**SSD 6626 - SICEEP Darling Square - Mixed Use Residential  
Building within North-East Plot**

## SSD 6626 Submission

SICEEP - SSDA7 Shadow Study

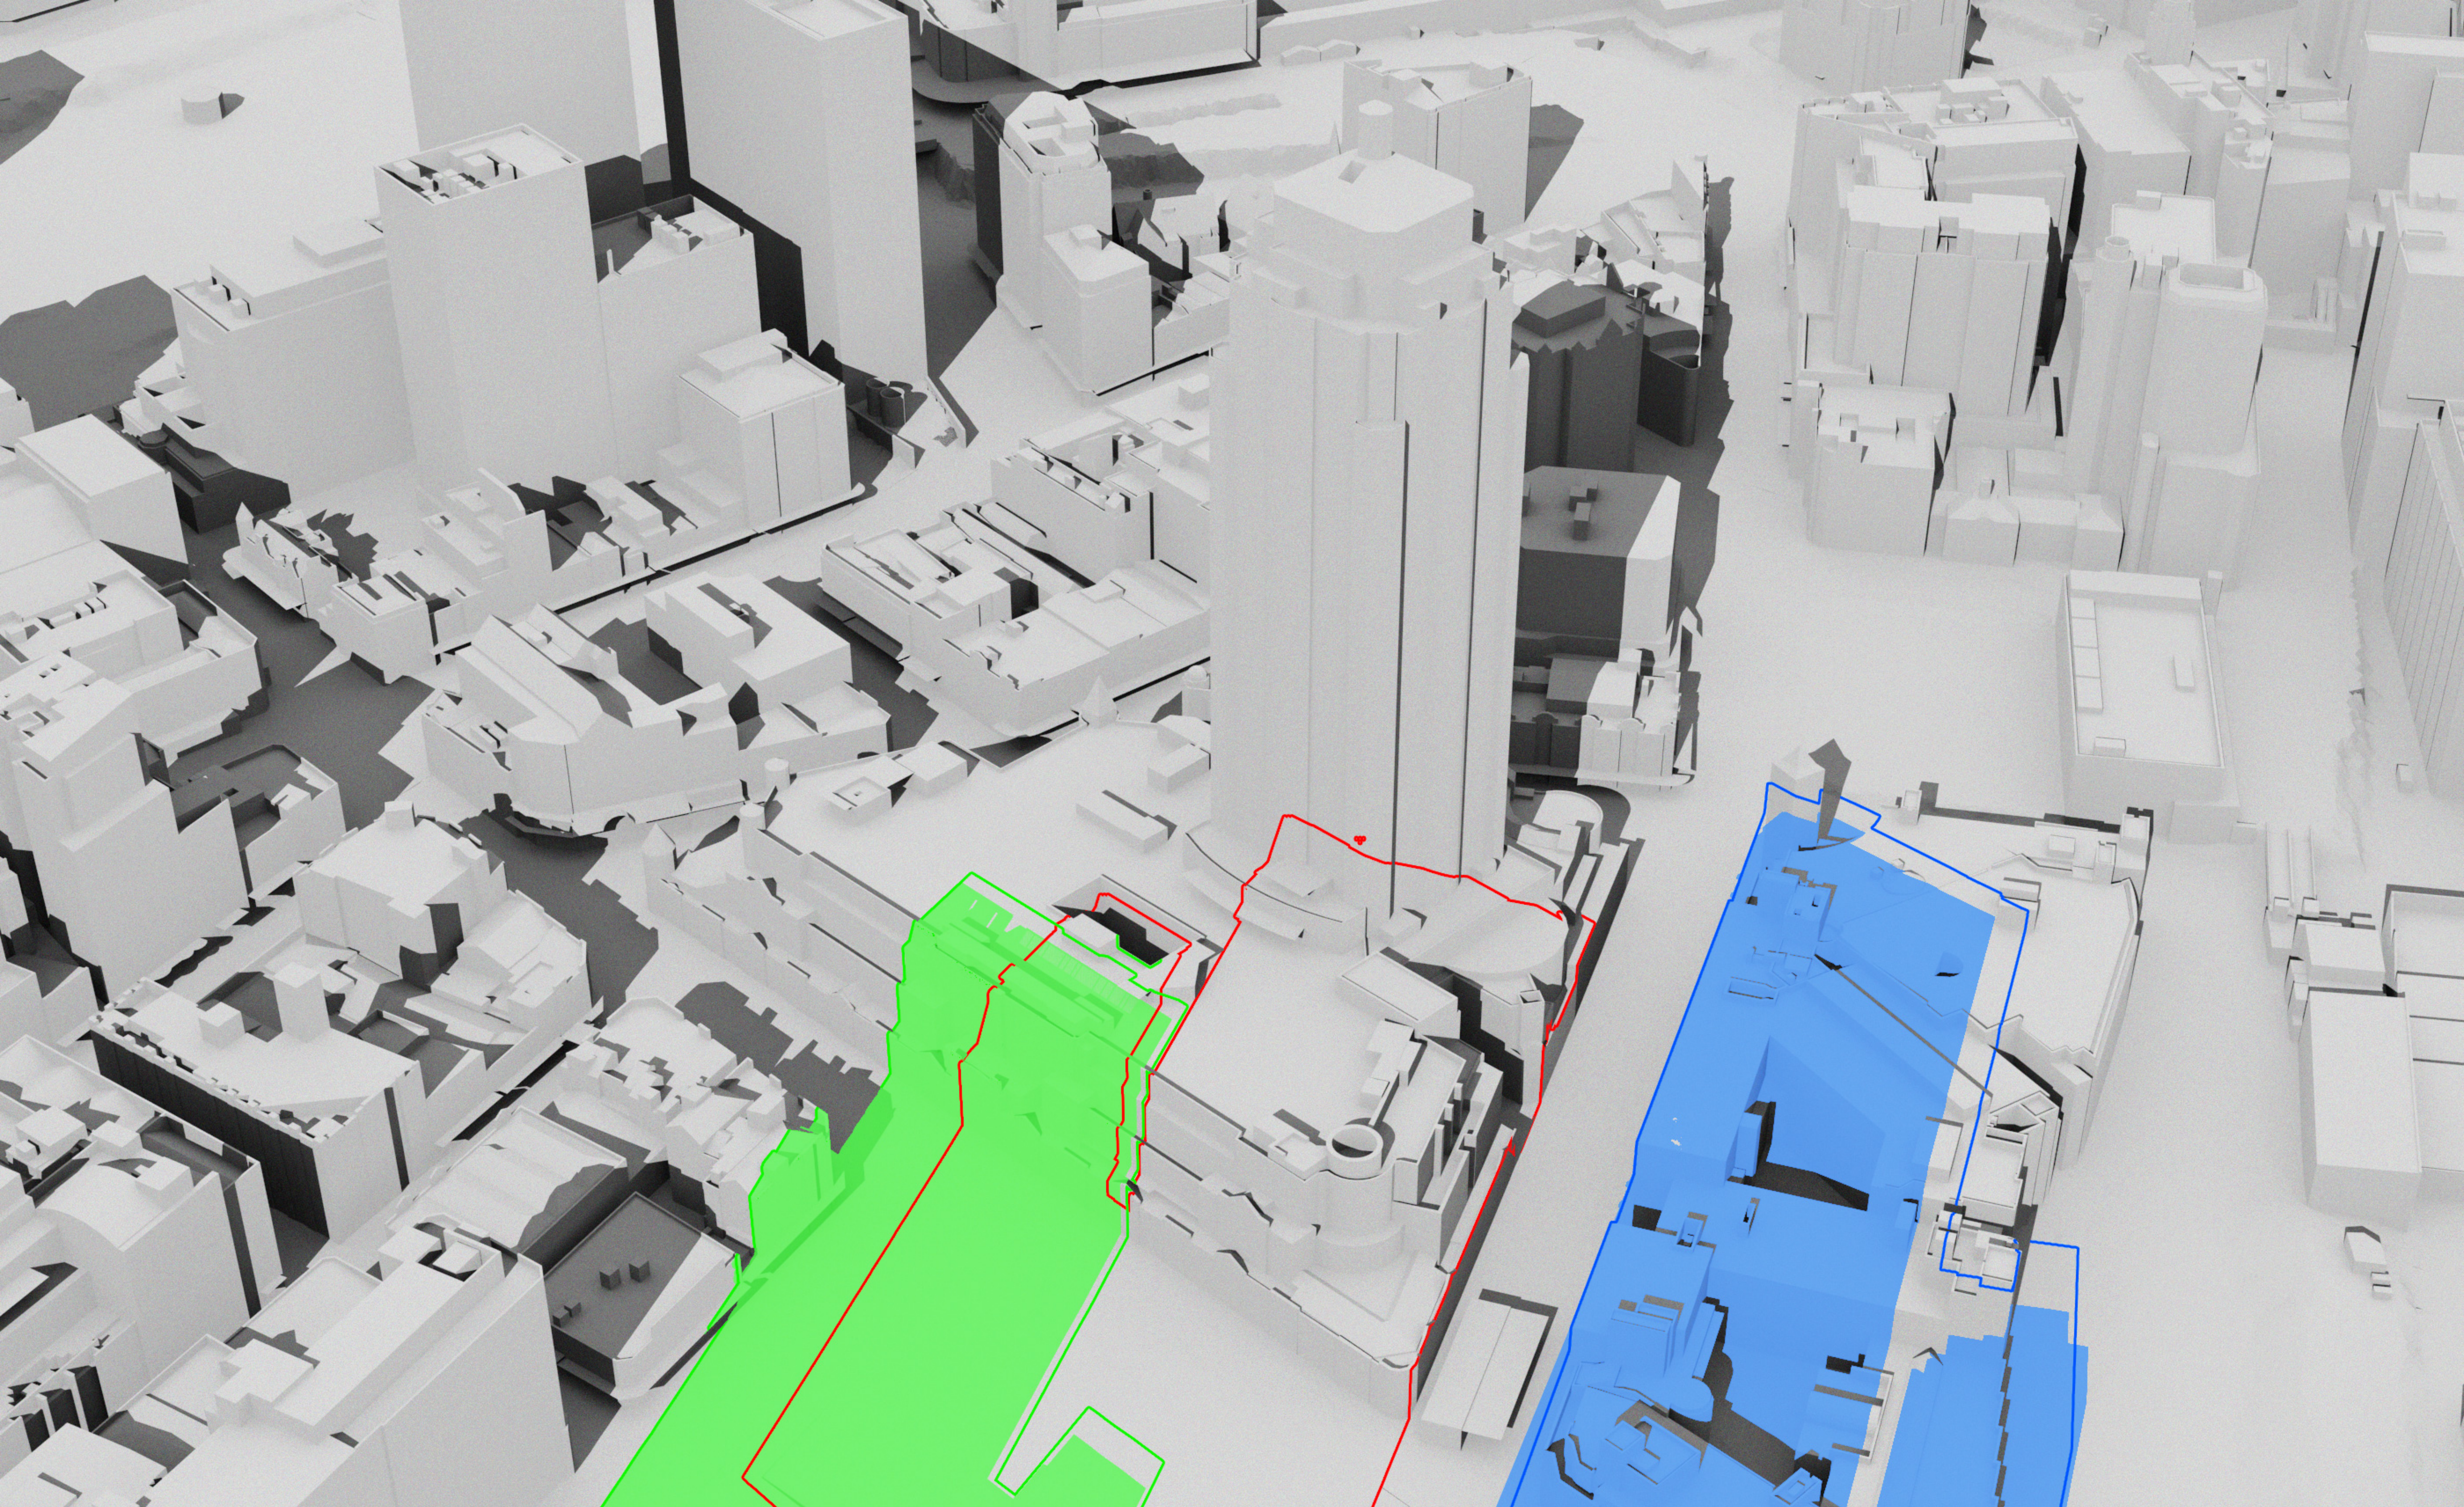
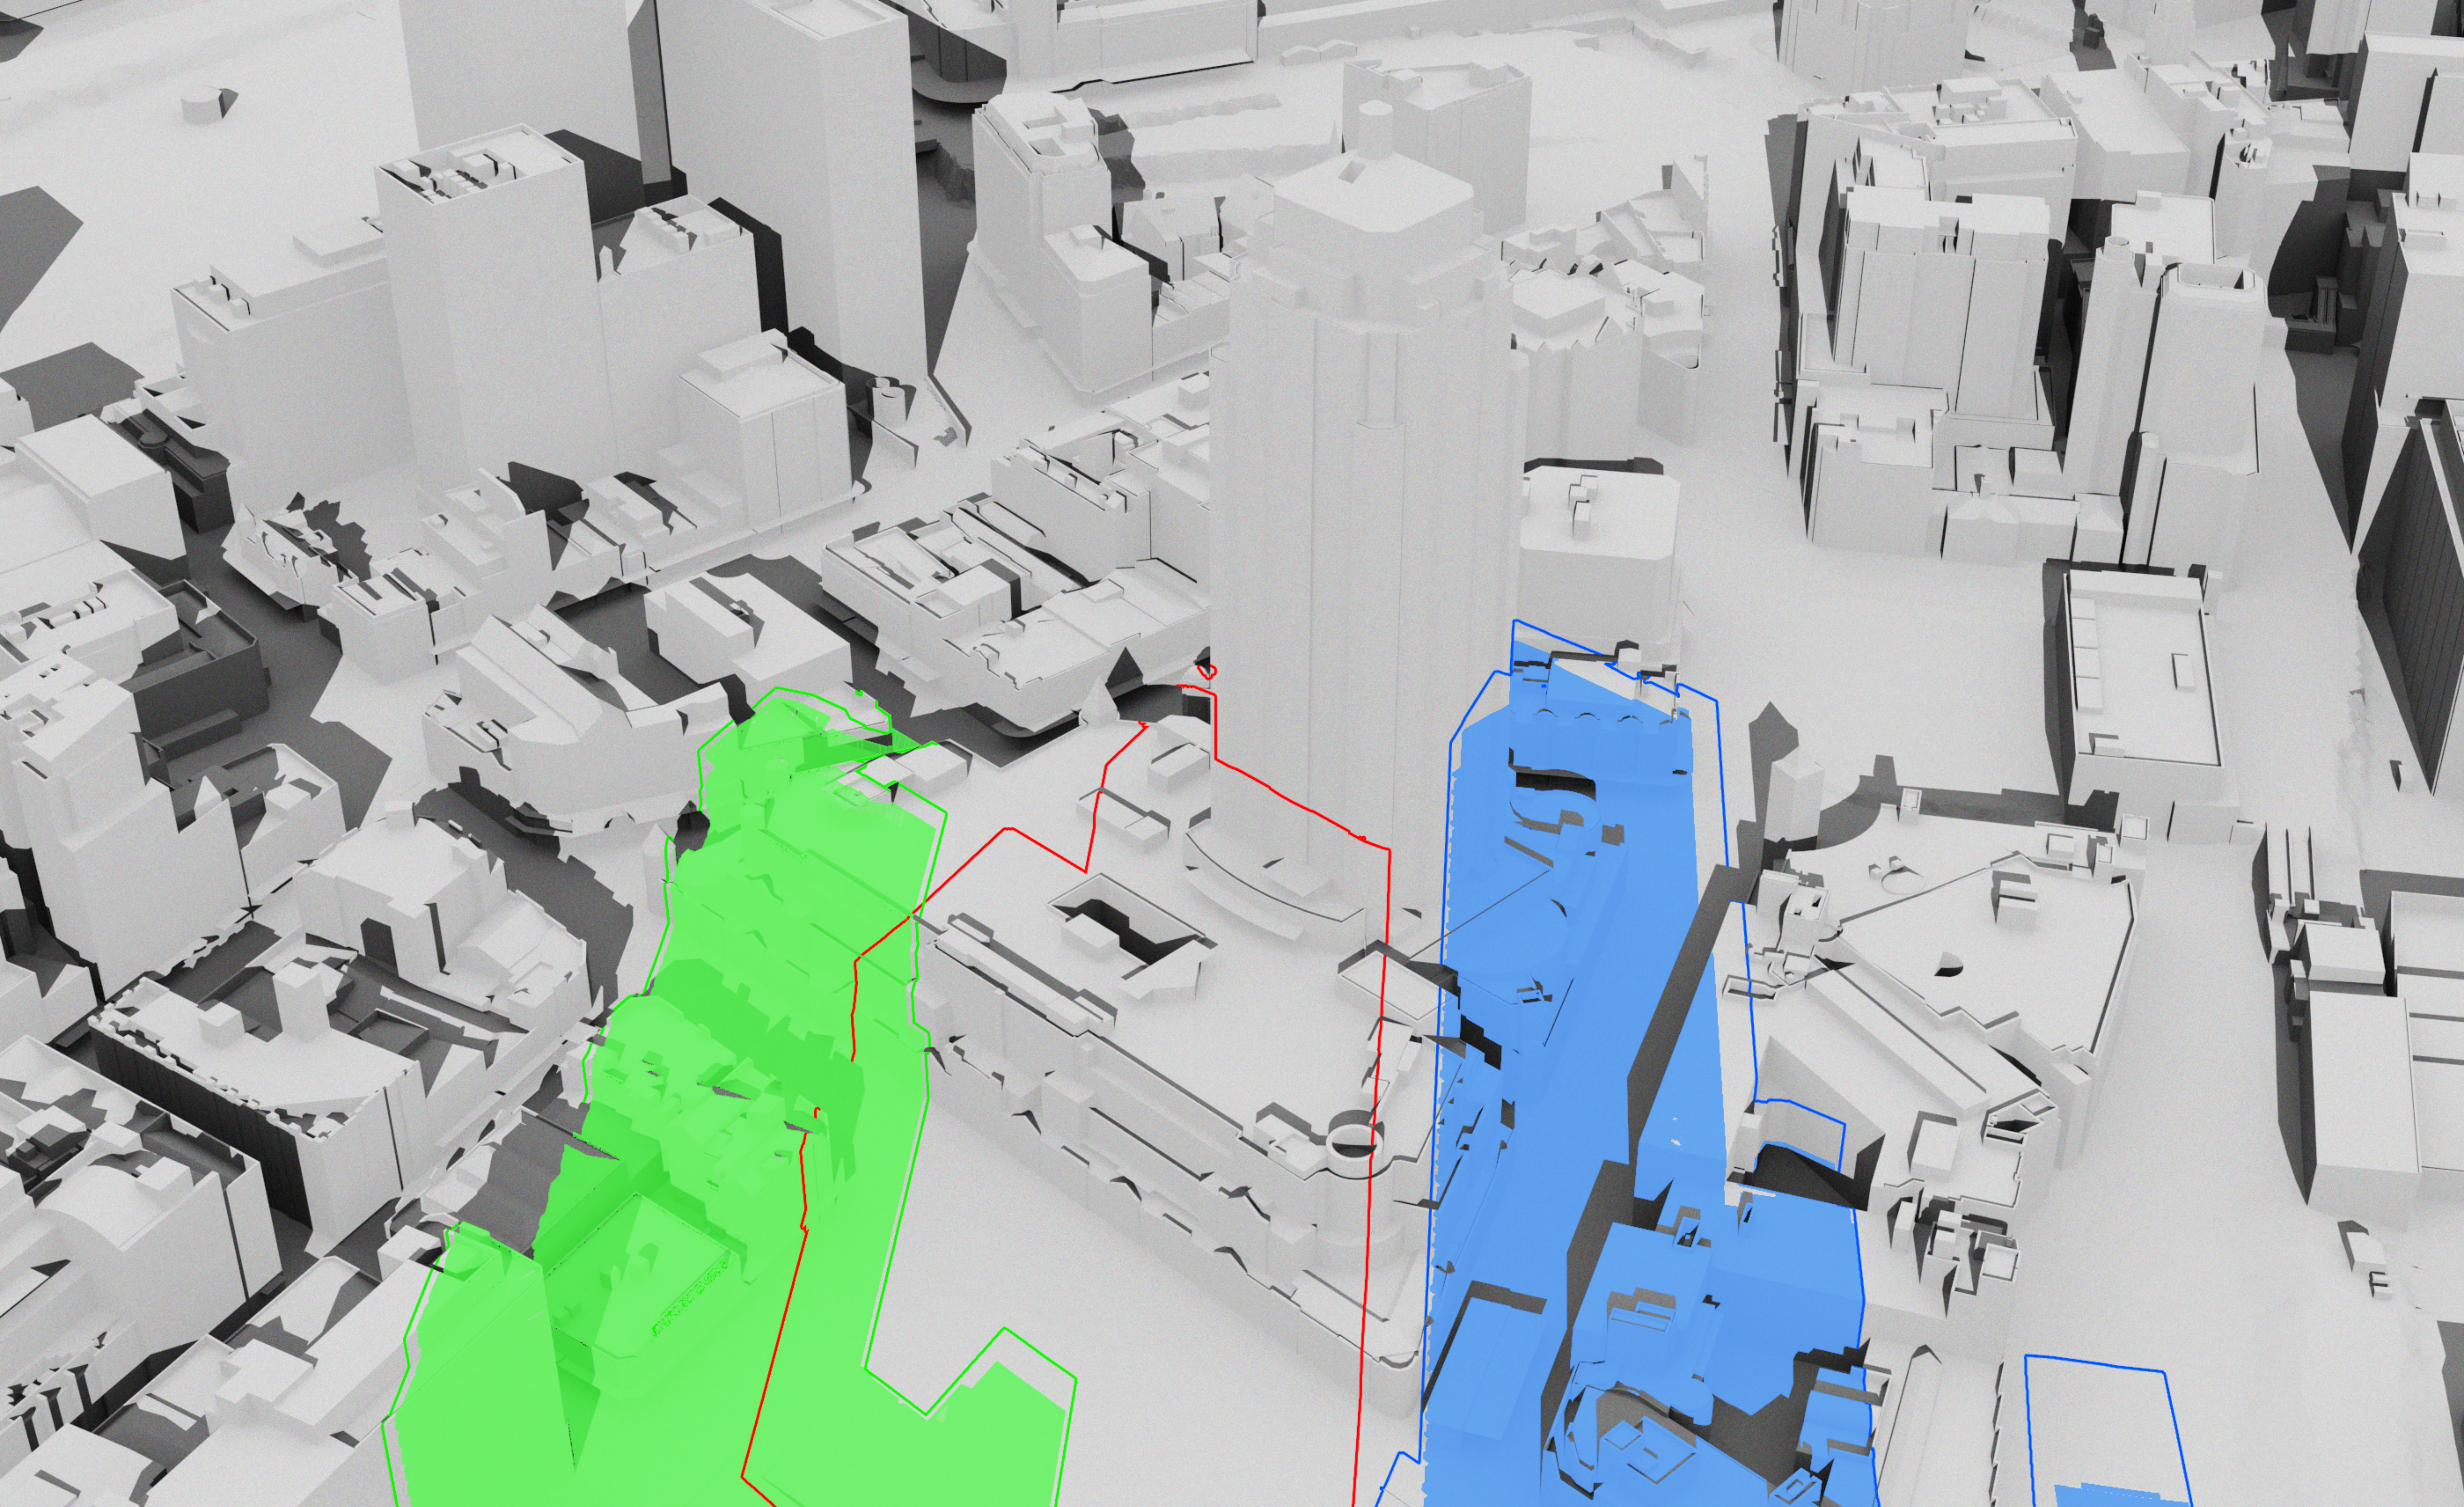
With respect to the podium of The Peak Apartments, the EIS states that "The landscaped podium associated with The Peak Apartments will continue to receive at least two hours of solar access, ensuring compliance with the intent of the Sydney DCP 2012.". Although this statement is true, two hours is a major reduction from the existing 21 June daylight access of about six hours.

There is no overshadowing of apartments in The Peak by the NE plot. The overshadowing is by the SW plot being developed by the same proponent.

We take this opportunity to reiterate our submission on SSD 6011 (SW Plot) which stated "It can be concluded that, as a result of combination of the proposed (SW) development with existing shadowing of the west façade, some single aspect apartments on the west façade and the south-west dual aspect corner apartments which currently receive less than 2 hours direct sunlight to habitable rooms and 50% of the private open space between 9am and 3pm on 21 June will suffer additional overshadowing. " At the time of designing the development, the proponent was, despite having made numerous site visits, unaware that there were single aspect apartments in the Peak. The proponent now belatedly accepts that there are 110 apartments in the Peak which are single aspect west or north. The proponent's response to not meeting DCP overshadowing standards for those apartments was "The Sydney DCP does not apply to the SICEEP site." (SSD6011 South West Plot SSDA5, Response to Public Submissions, p2). Presumably the proponent will make the same response on any point where its standards fall below those of the Sydney DCP. And the consent authority is apparently not concerned by adopting standards below those of the Sydney DCP.

We agree with the City of Sydney's view that "excessive morning shadows are cast into the outdoor and café areas in the new square by new surrounding building edges. In order to improve morning sun access to the square in winter, it is recommended that the building heights lining the new square be reduced and the floor area relocated to the surrounding streets podium edges..." Source: City of Sydney, SSD 5878 (SICEEP) The Haymarket submission, page 34.
